Application by National Grid Electricity Transmission (NGET) for a Development Consent Order (DCO) for the proposed Norwich to Tilbury Project (Application Reference: EN020027).

Essex County Council (ECC) Norwich to Tilbury Deadline 5 Submission.

Norwich to Tilbury  
Figure: 7.12.F232\_HE24c  
Viewpoint HE24: Church of St Marys Washbrook

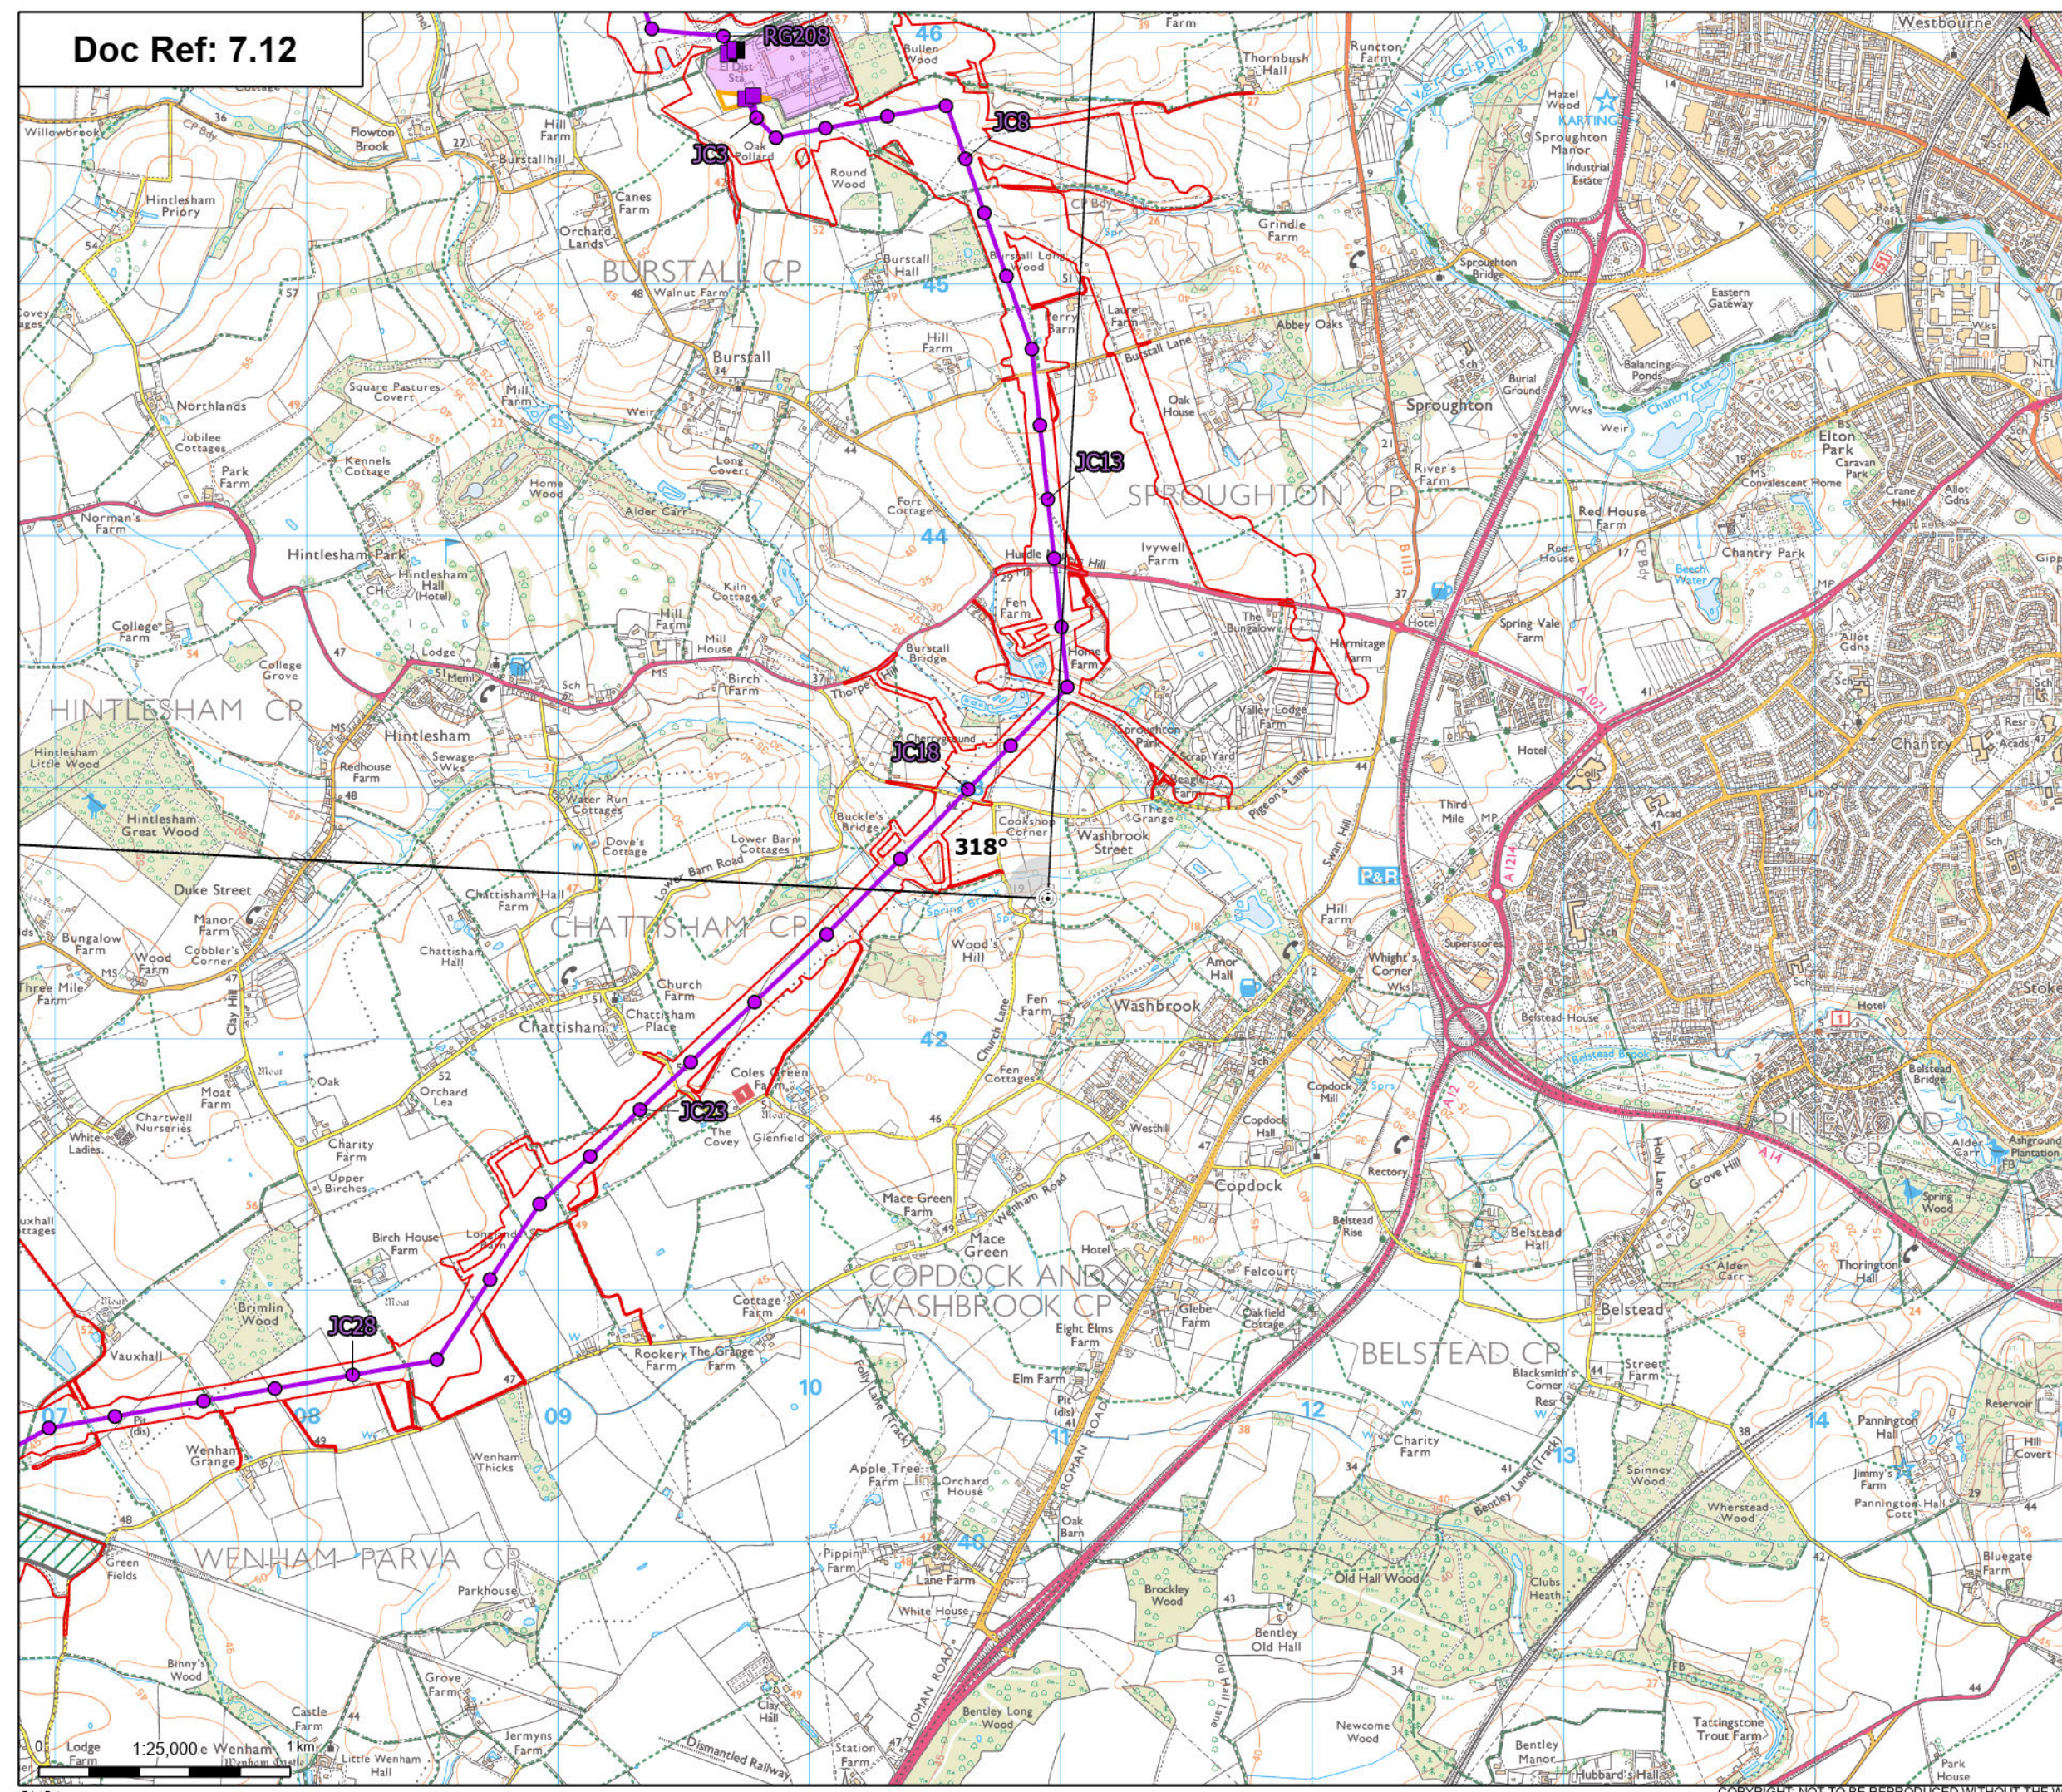
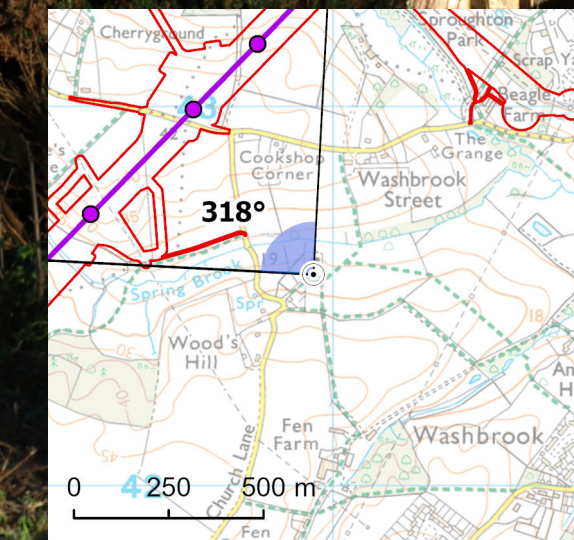
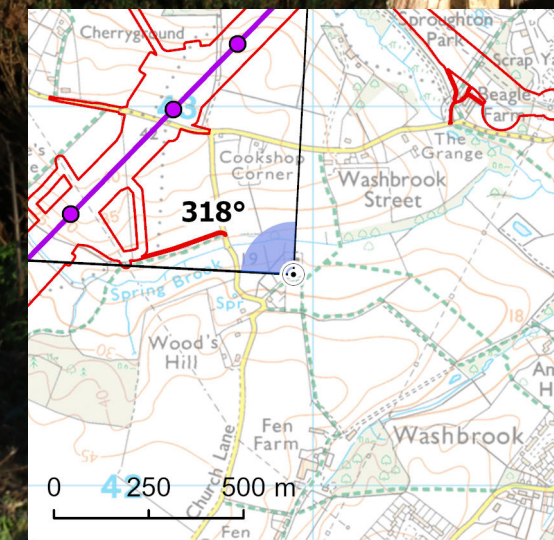
- 3.36. ECC considers that whilst the provision of the Photomontages are useful, the wirelines provided for RVAA only represent 3D form of the Project with only some topographical information, there is no context of these within the existing views and therefore provide very little in terms of representing appropriate views.

Title:  
 Figure 7.12.F83\_VP3.14a  
 Viewpoint 3.14: Lodge Lane, Ardleigh  
 Reservoir

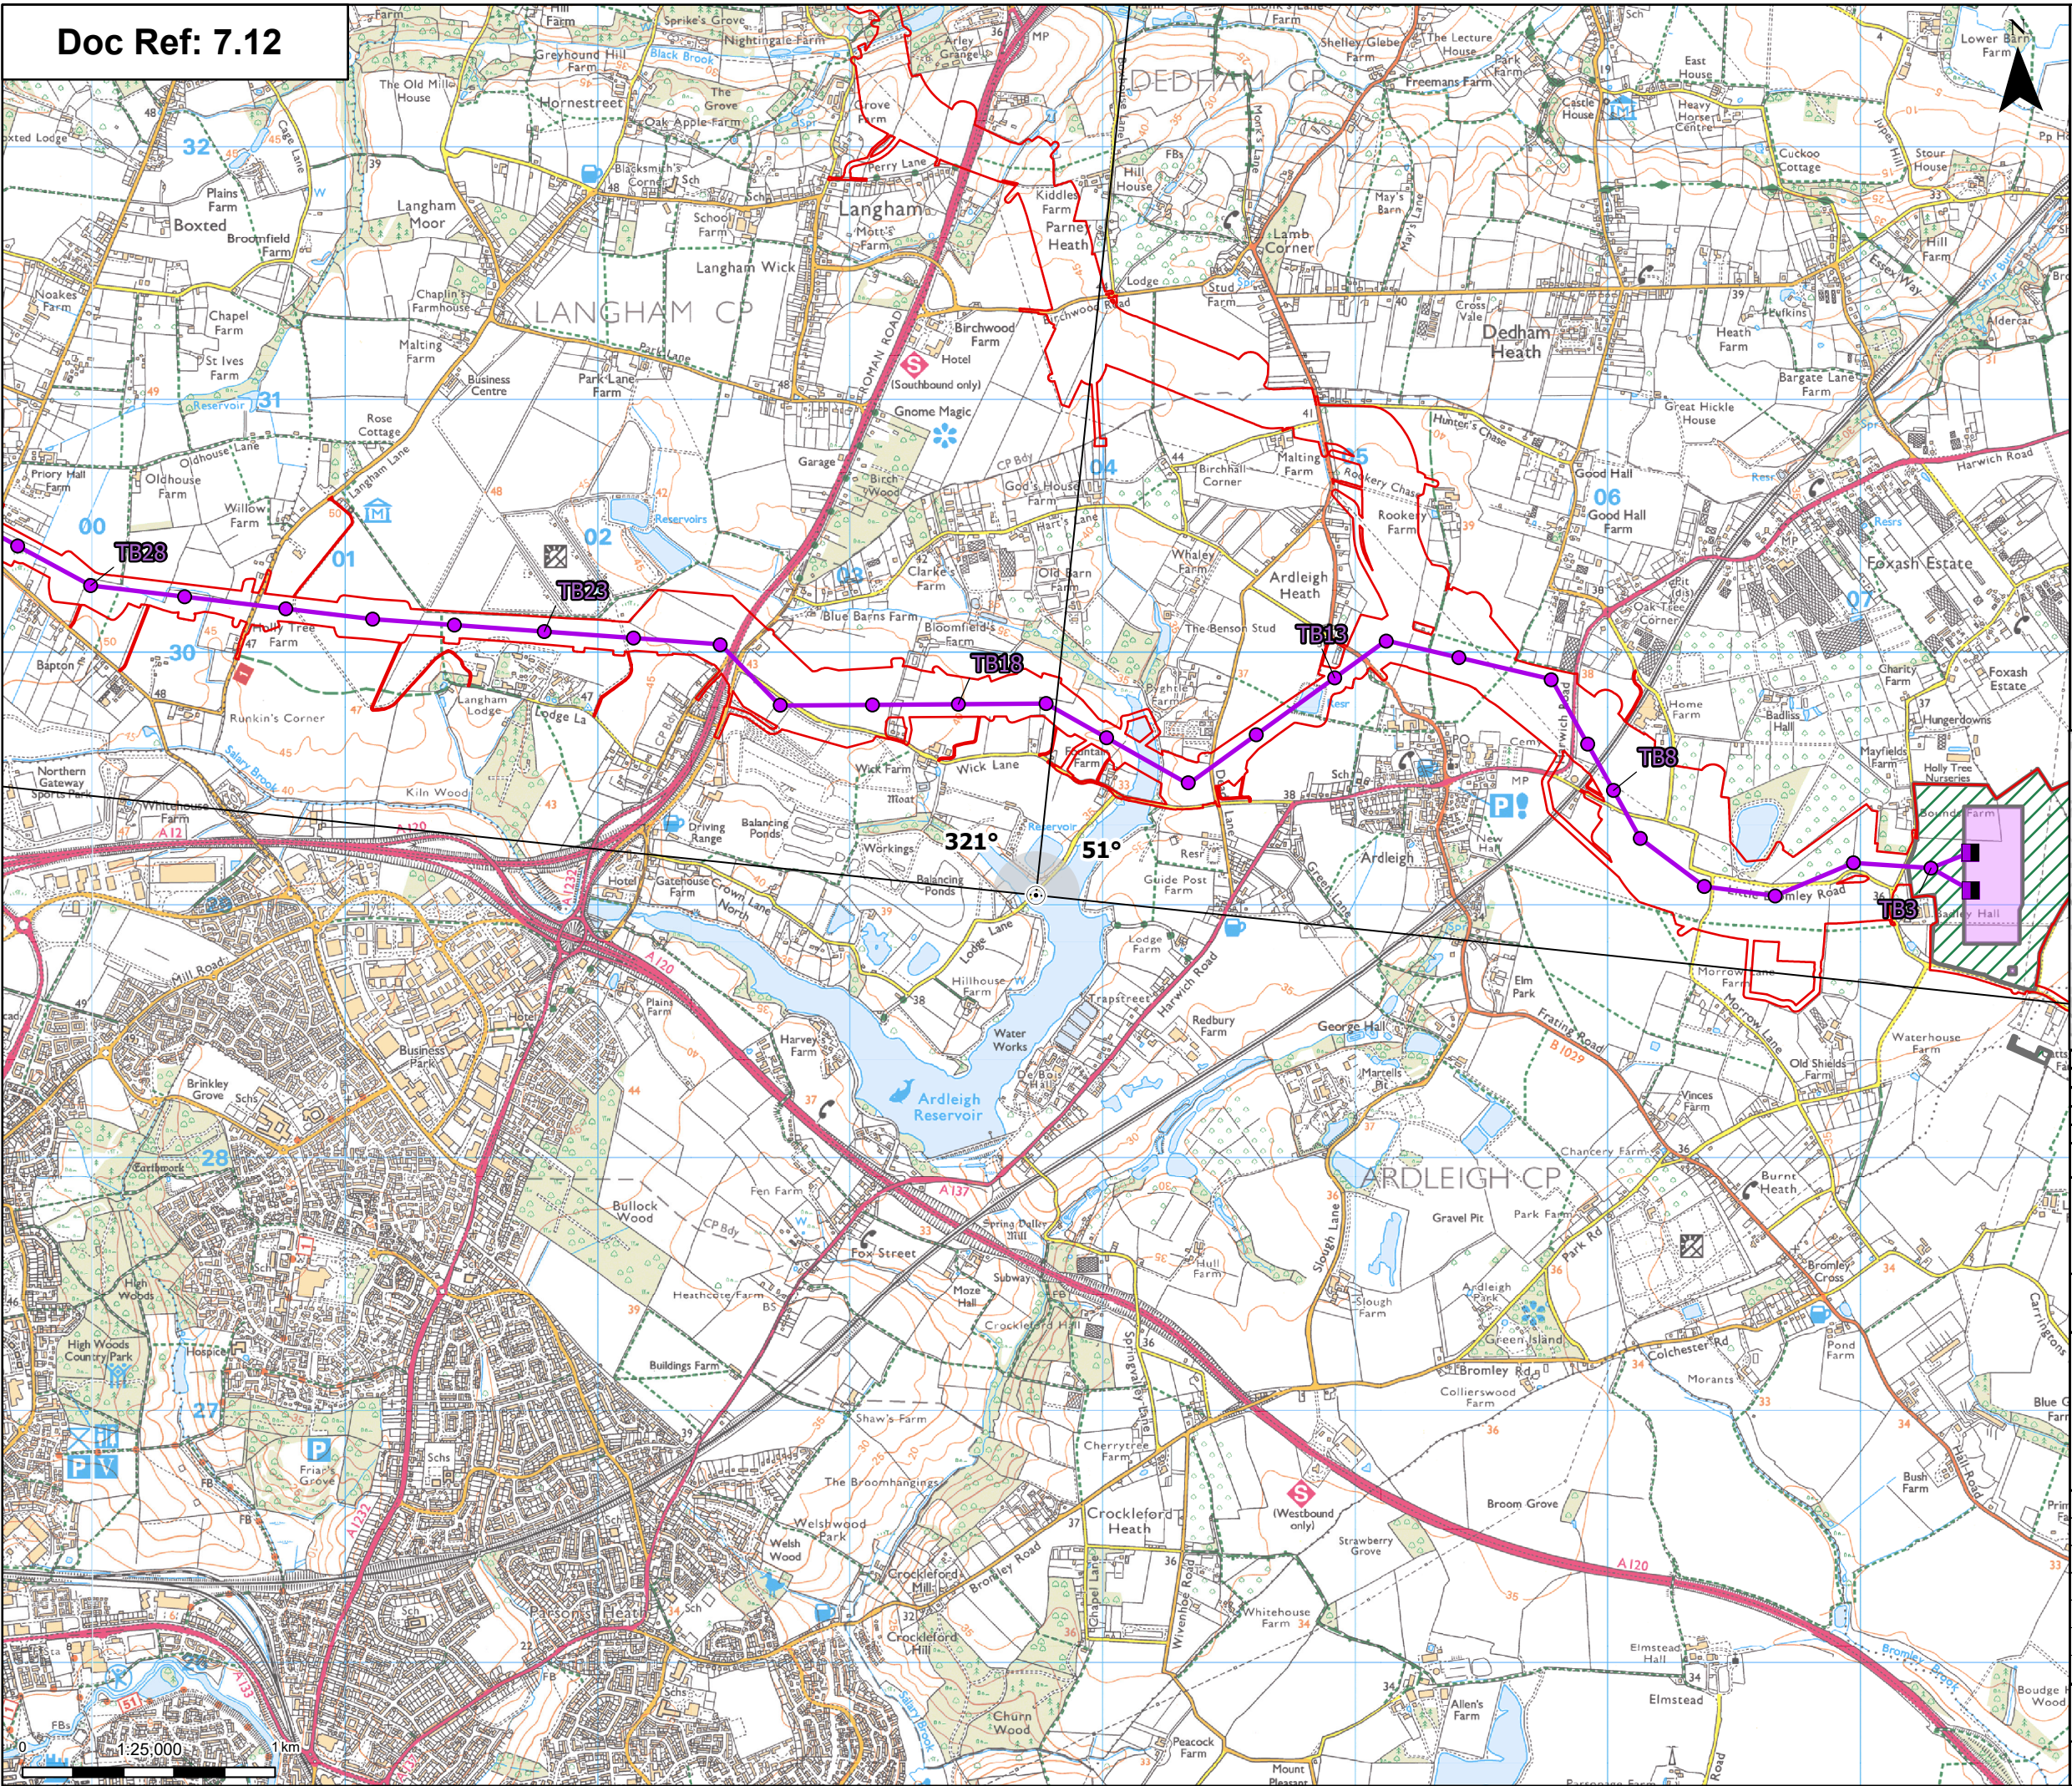
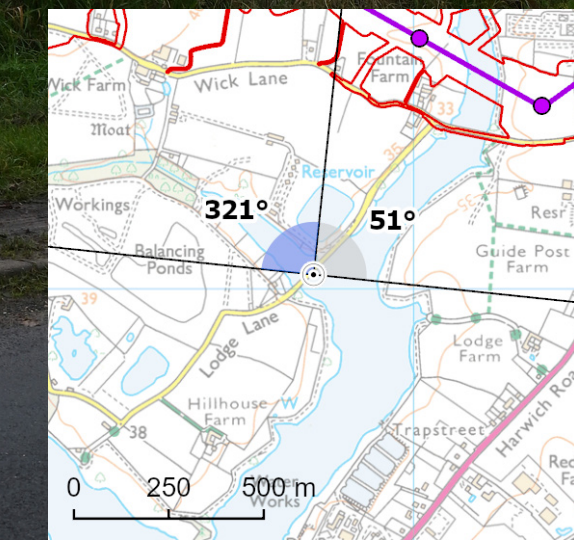
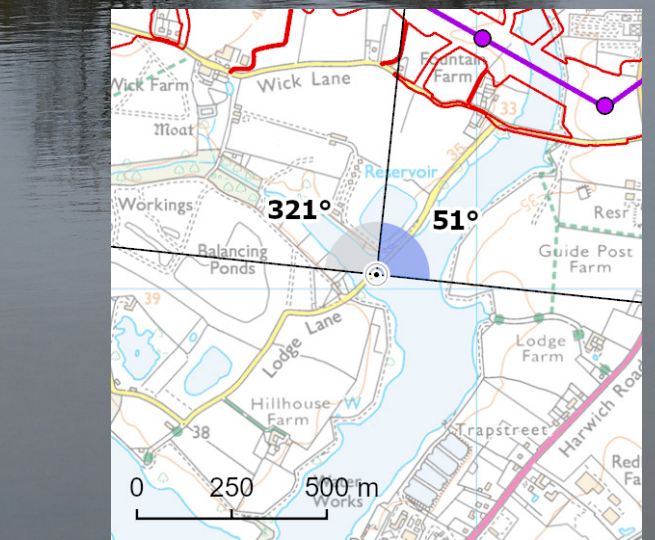
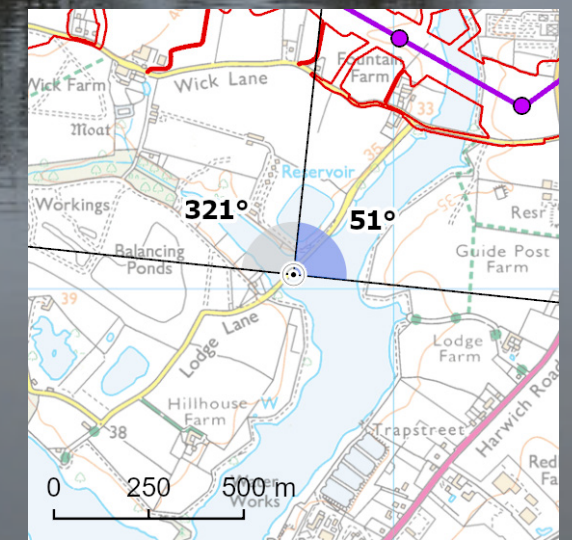
- 3.37. ECC does not consider it appropriate to take photography from behind a temporary visual obstruction.
